Recommendation Report for Planning Permission

REF NO: LU/106/15/PL

LOCATION: Willowbank Cottages
The Poplars
Littlehampton

PROPOSAL: Variation of condition 3 imposed under planning reference LU/203/13/ to enable the reorientation of plots 5 & 6.

SITE LAYOUT PLAN

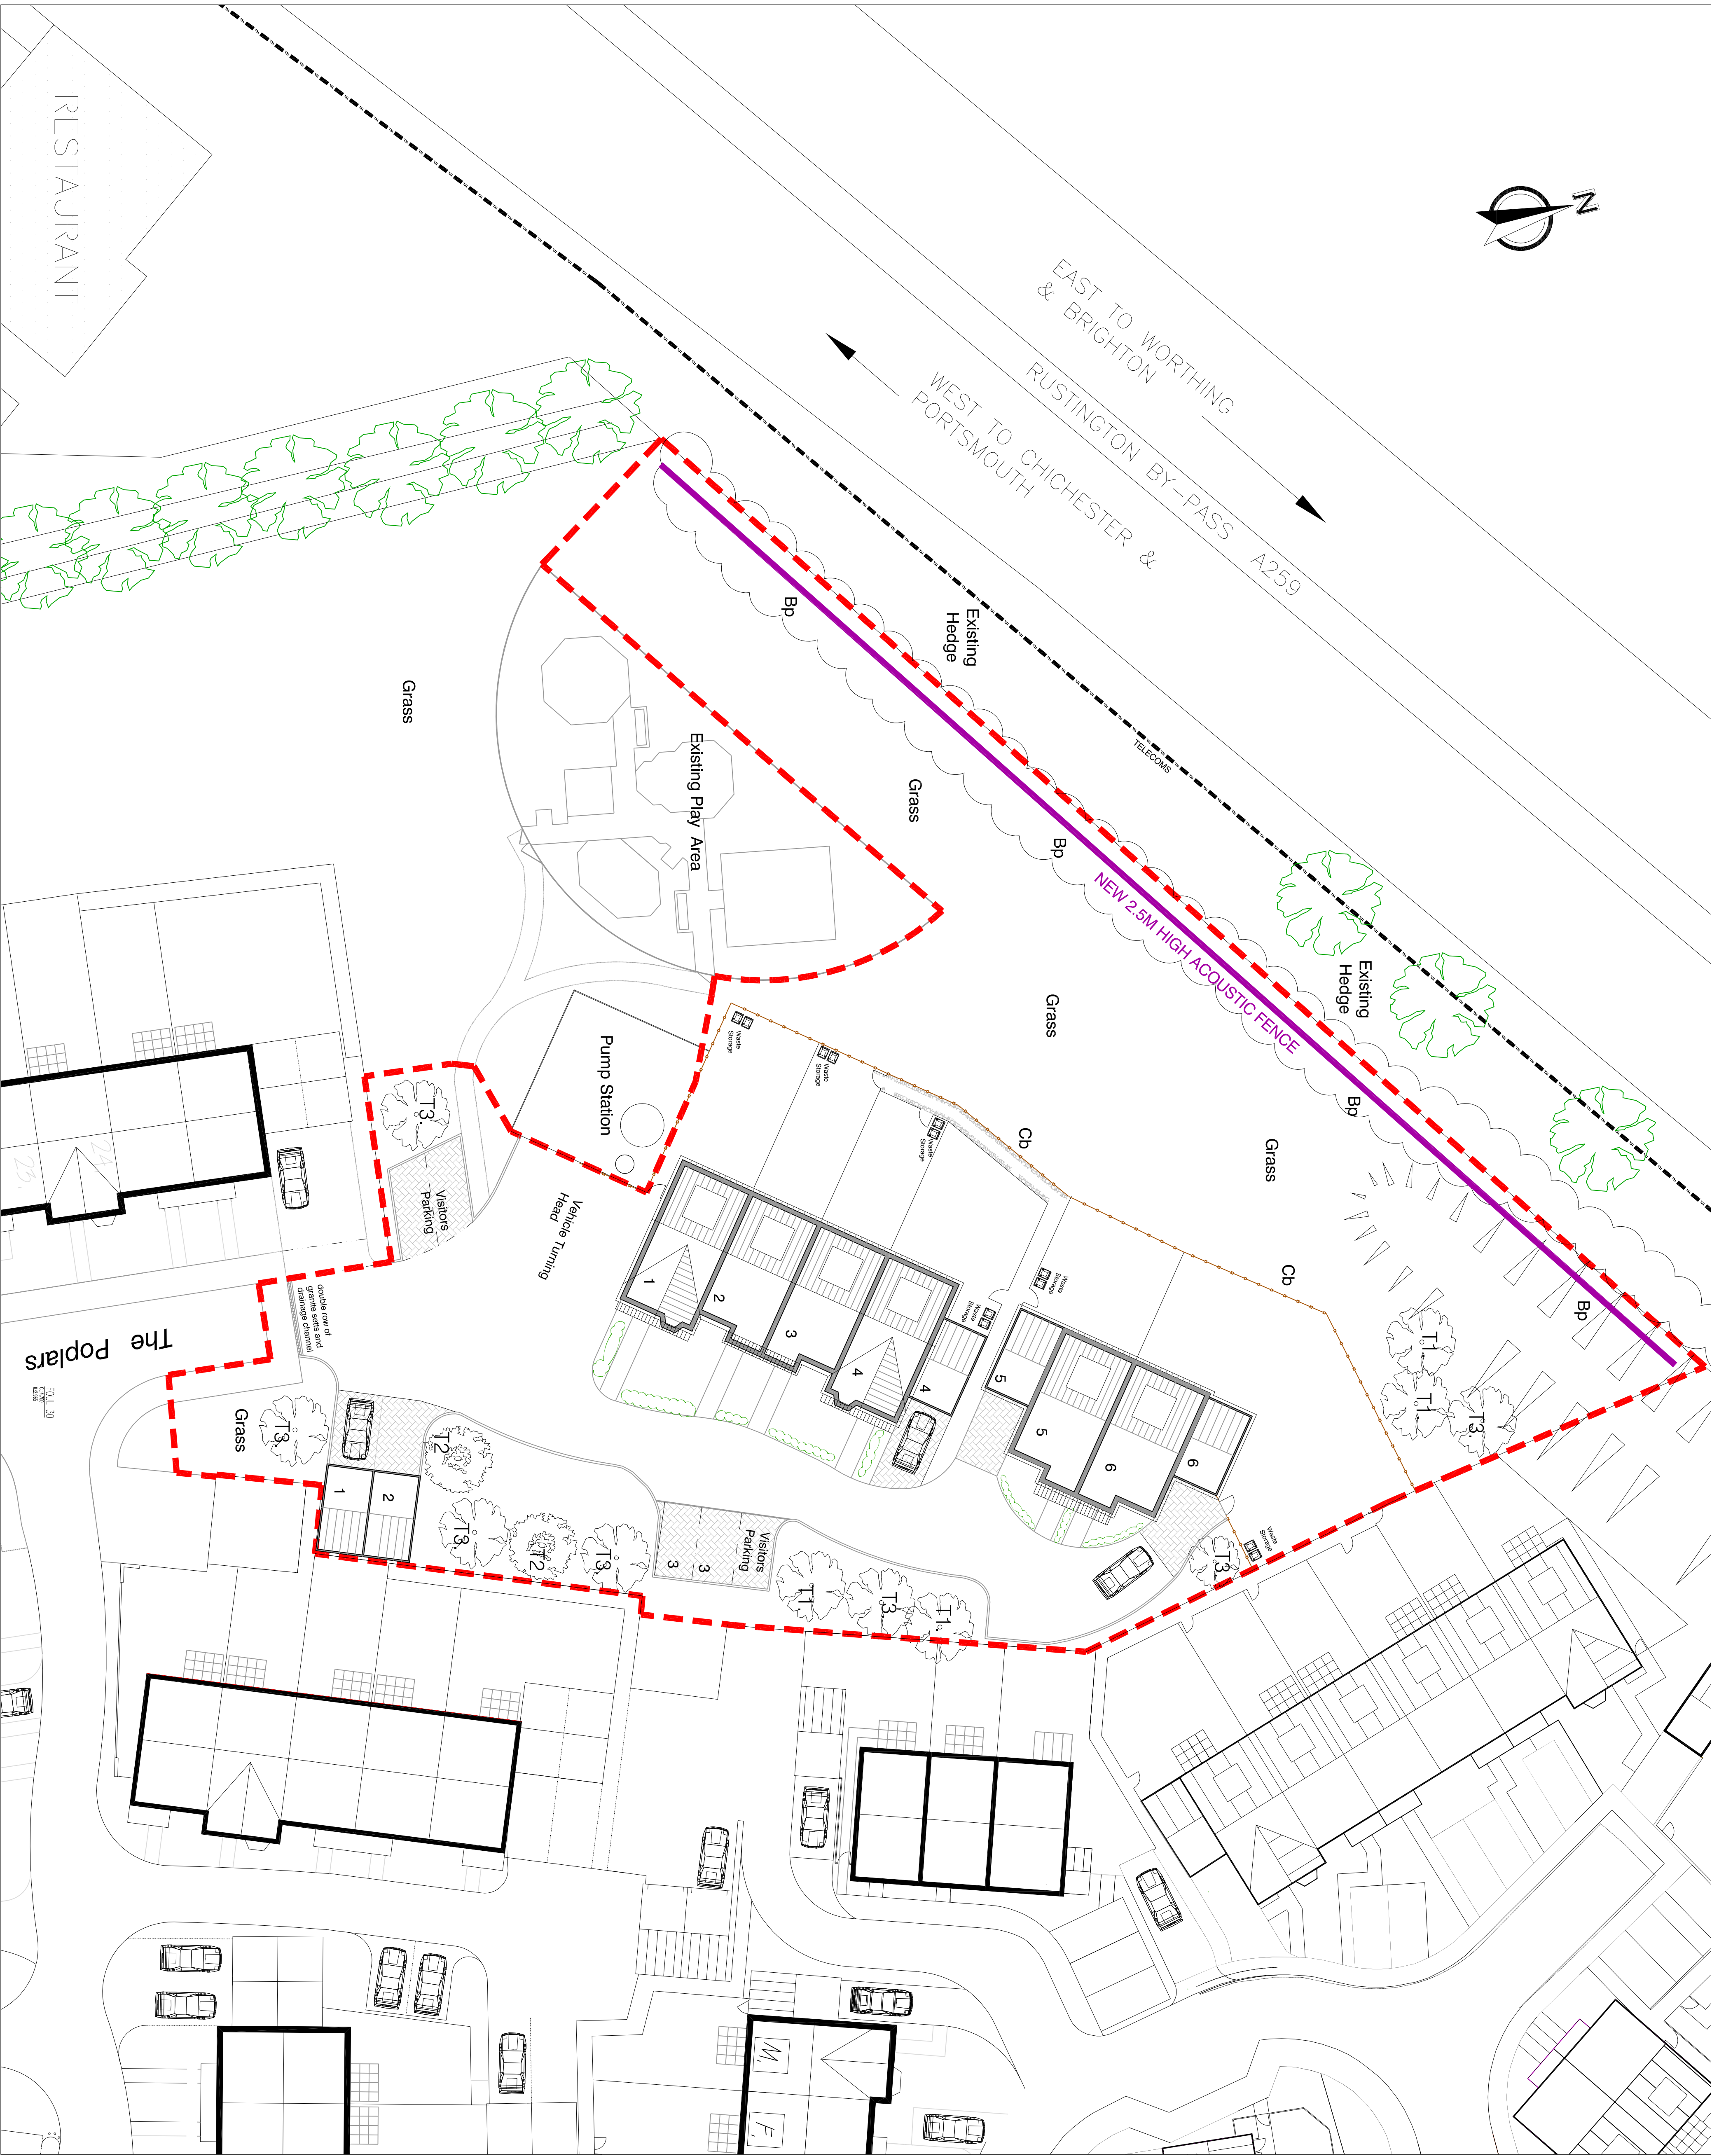
The scope and content of the development remains the same as that previously approved, with a change to the siting of the pair of semi-detached houses on Plots 5 and 6. On the approved site layout (drawing 023 001 100C), these 2 dwellings are shown with their front elevations orientated towards the south. The applicant advises that it has since become clear that the location of sewer and water supply pipes passing through the site, and the easement relating to these, is not as previously assumed. As a result, it is necessary for the siting of the houses at Plots 5 and 6 to be revised to reflect the actual alignment of the pipes, so as not to interfere with these. It is now proposed that the alignment of this pair of dwellings be rotated through approximately 80 degrees in an anticlockwise direction. This means that the layout of the development will

The proposed alteration to the previously approved layout also involves minor layout changes, namely repositioning the garages for Plots 5 and 6 (so as to be on either side of the semi-detached pair rather than both on the same side), and a revision to the garage for Plot 4 (setting it some 1.2m back along the side of that dwelling).

In addition, a pair of detached garages serving plots 1 and 2 which were located to the south of plot 1 and attached to it have been relocated so that they are now no longer partly in front of the existing pumping station. These are proposed to be located on the east boundary of the site and to the rear of nos. 14 and 15 The Poplars and to the immediate north of another pair of existing garages.

Southern Water comments that plots are too close to the pumping station and that no habitable rooms should be located closer than 15m to the boundary with the pumping station in order to avoid vibration, noise and odour generated by sewage pumping.

The layout as now proposed results in separation distances for the 2 plots to be relocated being at the closest 15m from proposed side to rear of existing dwellings. This separation distance rises to up to 20m side to rear. The front of the relocated dwellings would be between 19m and 20m from the rear of existing dwellings. These relationships are considered to be acceptable and to provide for satisfactory separation. In addition, the relocated dwellings would have no side windows. The proposed dwellings would not be unduly close to existing ones and unlikely to result in amenity loss/harm such that planning permission ought to be reasonably withheld.

The relocated pair of garages will result in impact on the dwellings which they would adjoin. However, they are grouped with existing garages and are no closer to those existing garages. Additionally, they will have eaves (2.15m) adjoining those dwellings and ridge lines (4.1m) at a greater distance away from the boundary (3.0m).

- 1 By proposing to site plots 1, 2 & 3 within 15 metres of an existing Southern Water pumping station the plots would be unacceptably affected by vibration, noise and potential odour generated by the pumping station in conflict with policies GEN7, GEN32 and GEN34 of the Adopted Arun District Local Plan 2003 and policy QE SP1, QE DM1 and QE DM3 of the Emerging Arun Local Plan 2011-2013.
